Re: Kicking Camel Grill Plan Review
174 N. McKinley St.
Coats, NC 27521

The food service application and site plan, submitted on 4-27, for the above referenced facility were reviewed, but cannot be approved at this time. Refer to the attached application cover sheet for a checklist of items that are required for plan review. Several of these items were not included with the application and must be submitted for review. Please review the following list and submit the requested information:

PLAN

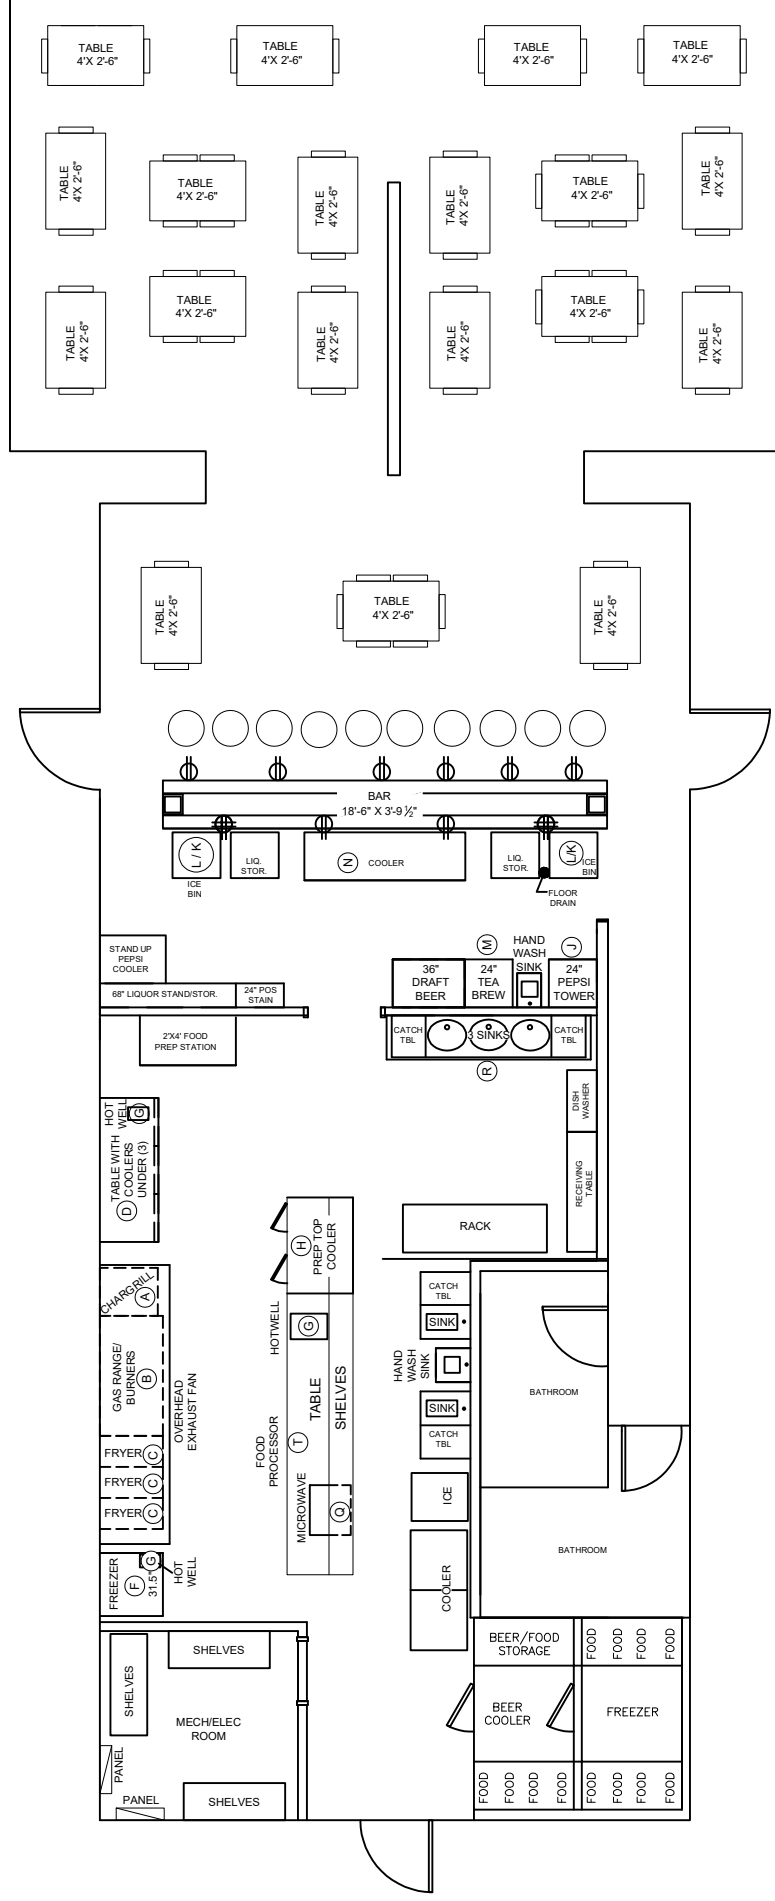
- 5- Application and food process sheets indicate you intend to hot hold the following: soups, sauces, potatoes, sausage gravy, chili, queso, hashbrown casserole, biscuits, homefries. A steamer well and/or hot holding cabinet is required to hold these items. Provide specification sheet of hot holding equipment and indicate on site plan location of hot holding equipment.

- 6- Indicate on plan the location of any of the following: microwave, blenders, toaster, and other tabletop equipment.

- 7- Provide location for storage of empty kegs.
- 8- Application shows you intend to have a chemical dishmachine Swisher EST-AH (250Estahx). A separate submittal shows Noble Warewashing HT-180 High Temp Machine as the provided dishmachine. Provide an equipment specification sheet for the machine you intend to use.
- 9- A floor drain in the bar area is not shown on the site plan.
- 10- Indicate location of Chargrill on site plan.
